CITY OF ALBUQUERQUE

Re: Carlisle and Menaul
Traffic Impact Study (H16D083F)
Submittal dated March 4, 2025
Via email cvermillion@bhinc.com and ABQ-PLAN

The Traffic Impact Study (Study) received on April 2, 2025, has been reviewed by the City of Albuquerque Planning Development Transportation Section and has the following comments.

D PROPOSED CROSS SECTION
NTS

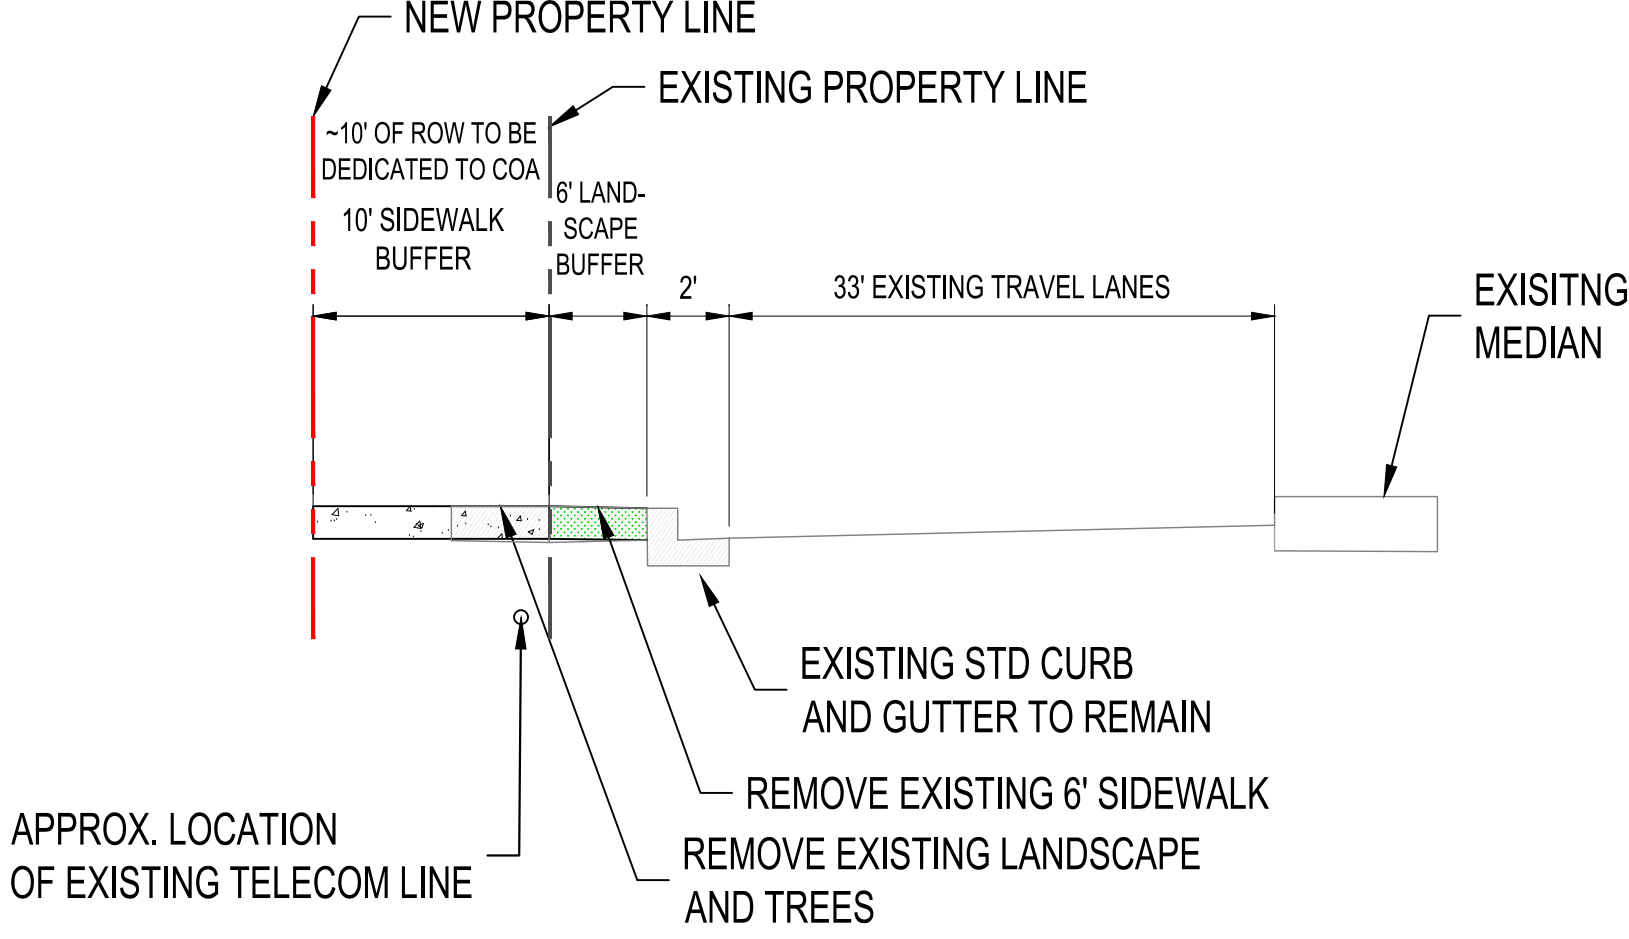
1. I would like to see a sketch of the proposed median change on Carlisle for Access #4. I want to make sure of what this will look like. In addition to the median changes, please show a “pork chop” at the entrance to indicate to drivers that it will only be right -in, right out.
